**cPort Credit Union 50 India St., BP# 2017-01518**

Below are my responses per our conversation yesterday.

A920

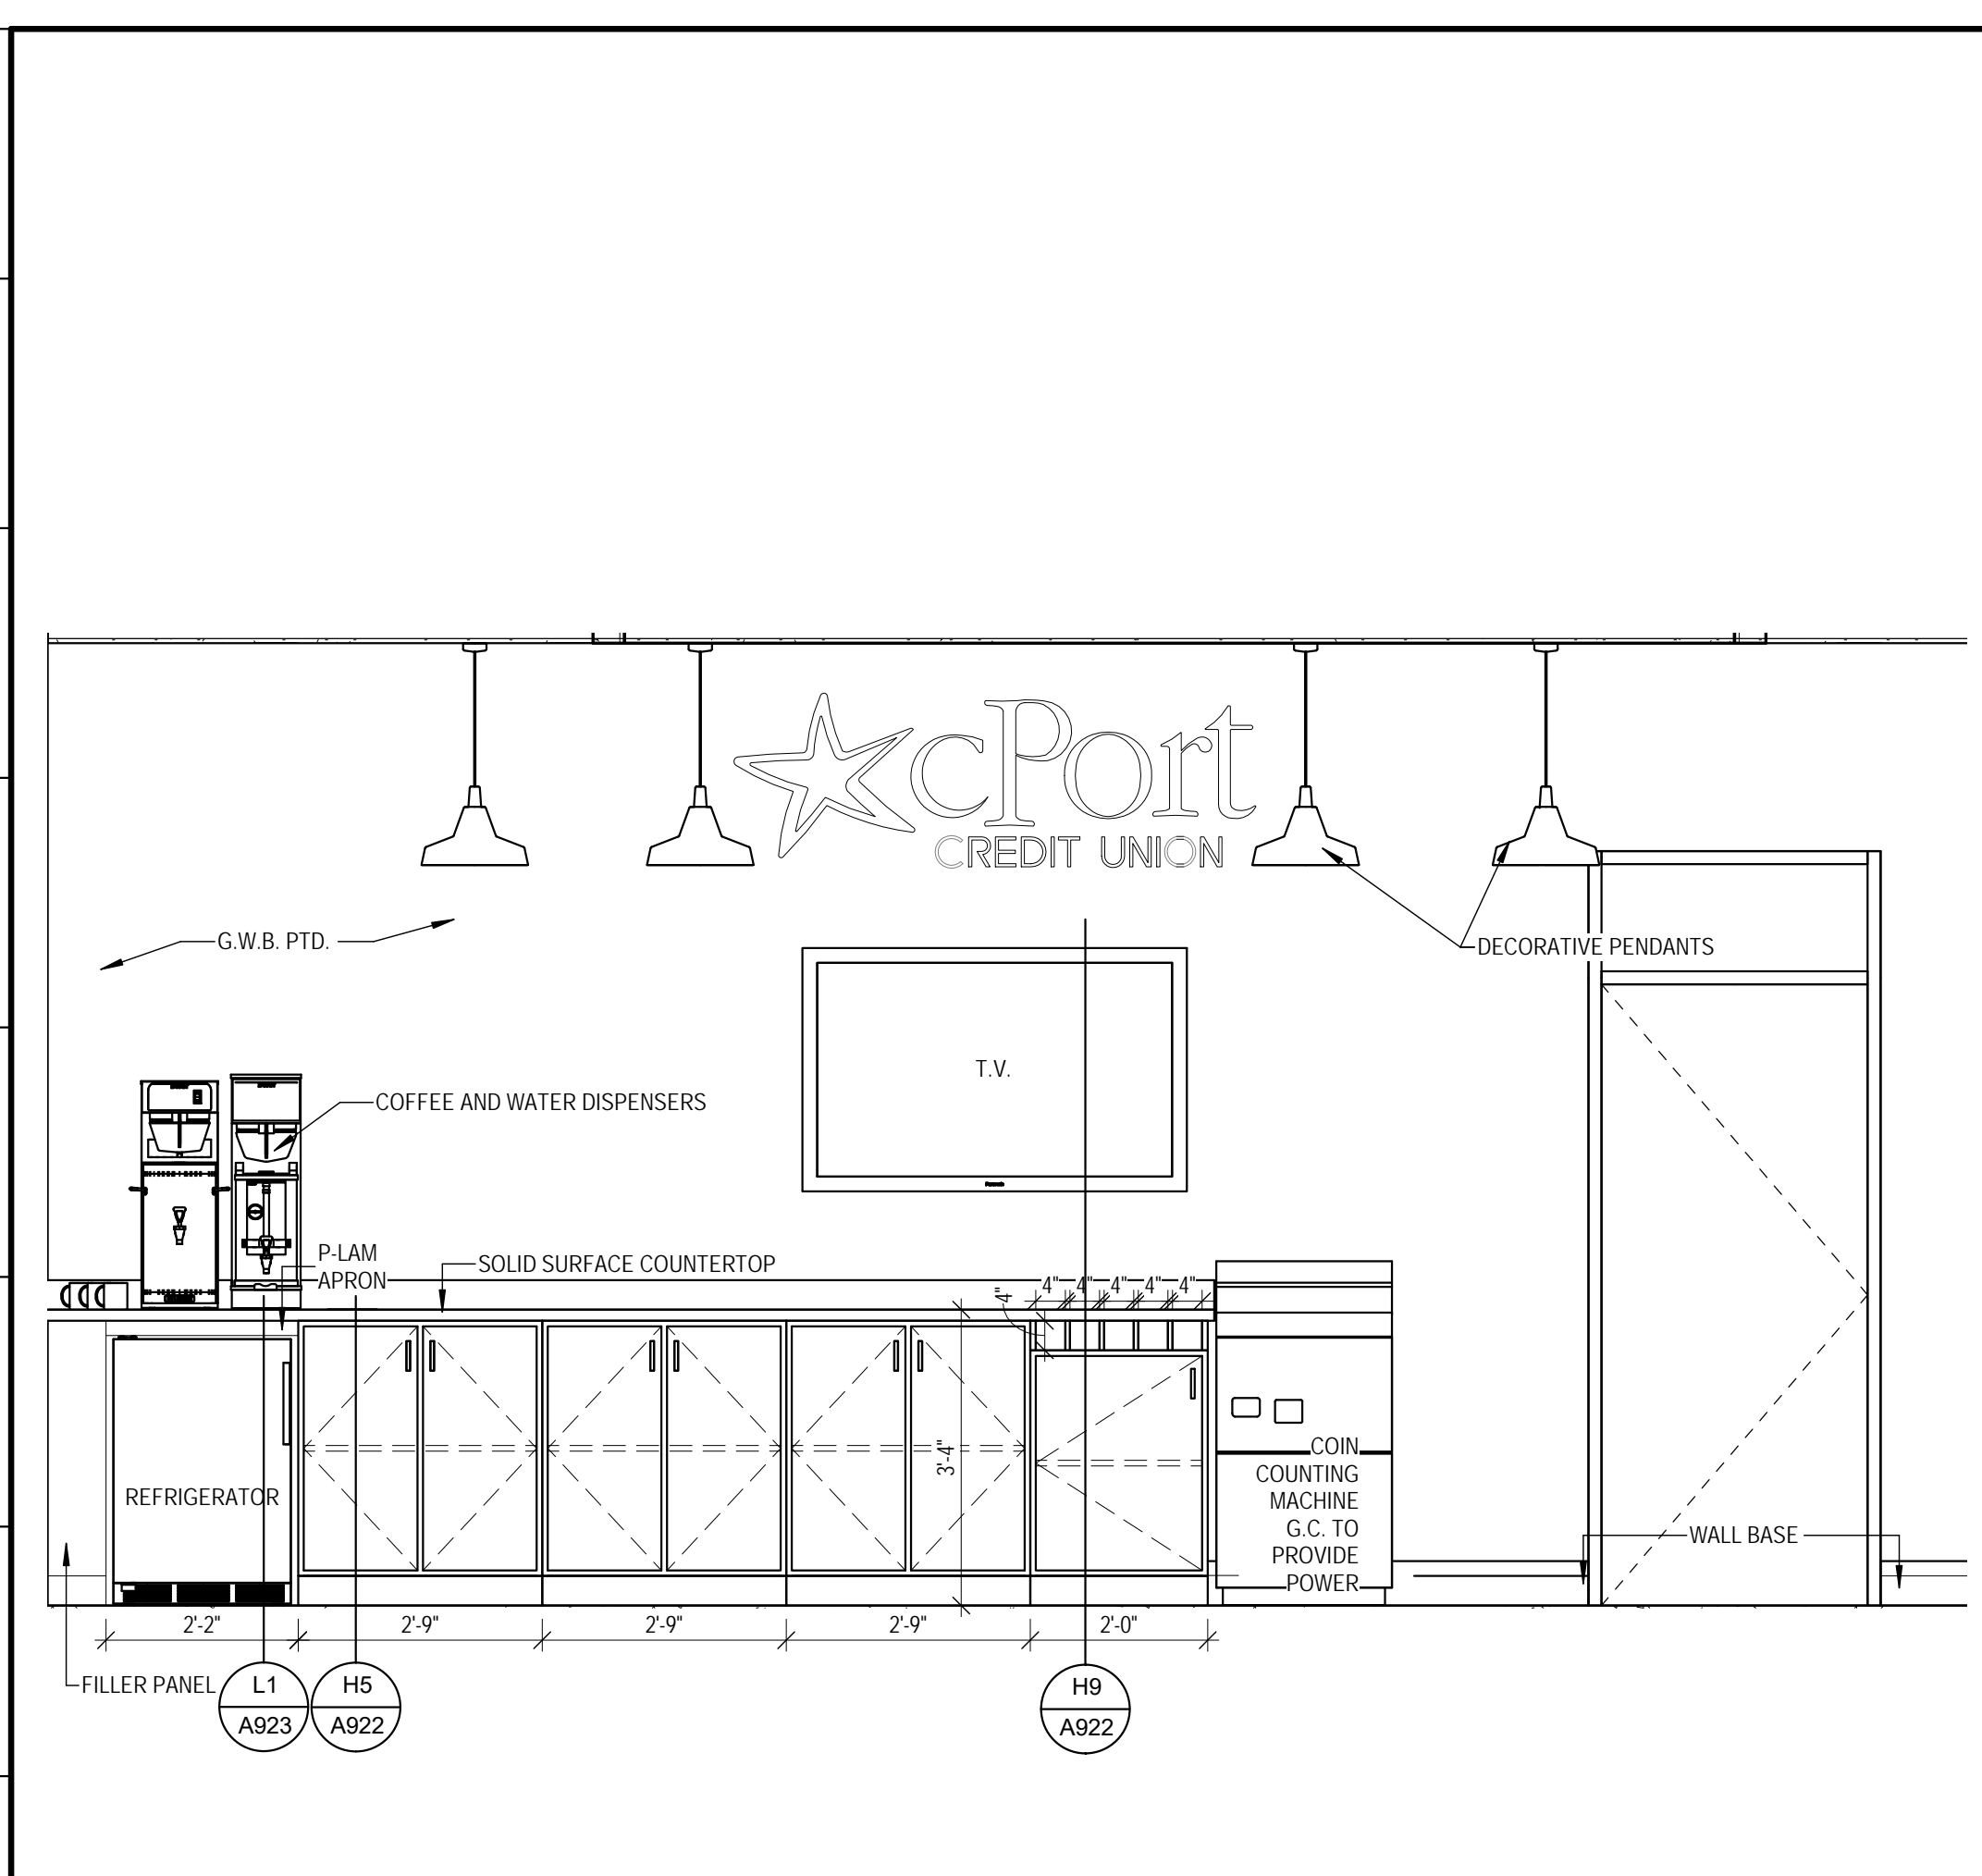
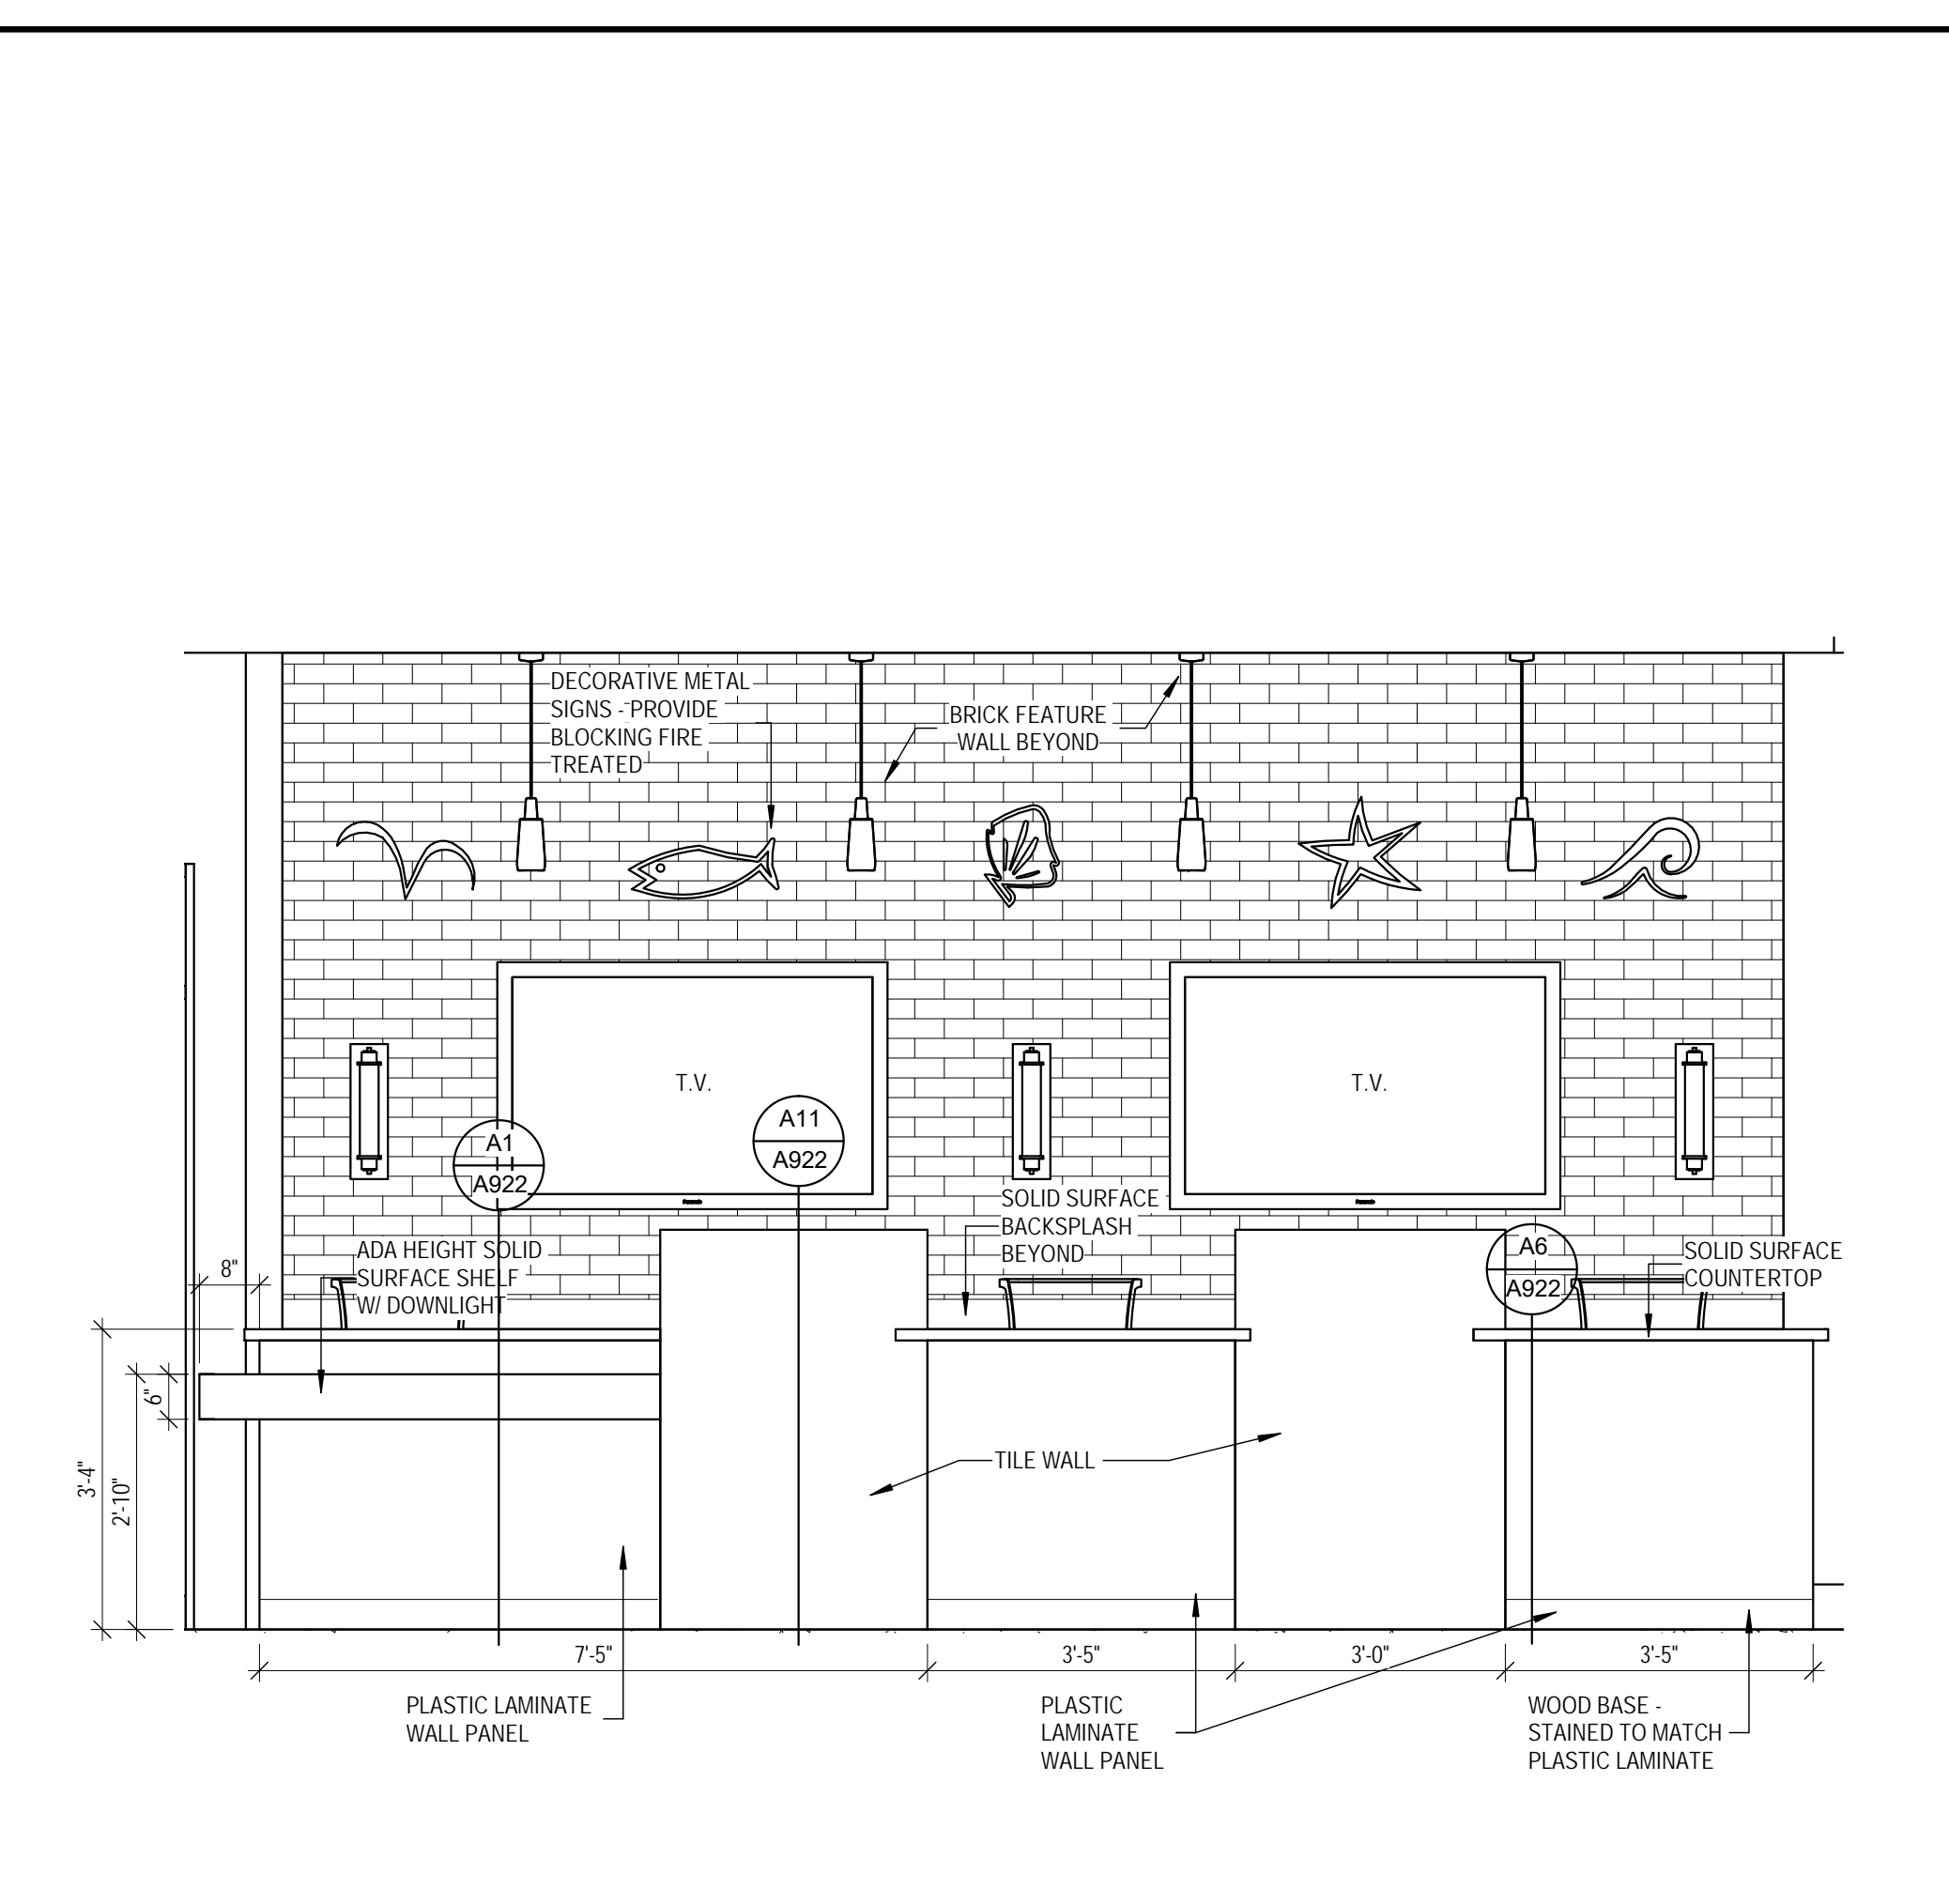
6. Sheet A920 – Counter height was modified at the coffee station and an additional trash receptacle was added below the counter. See attached pdf
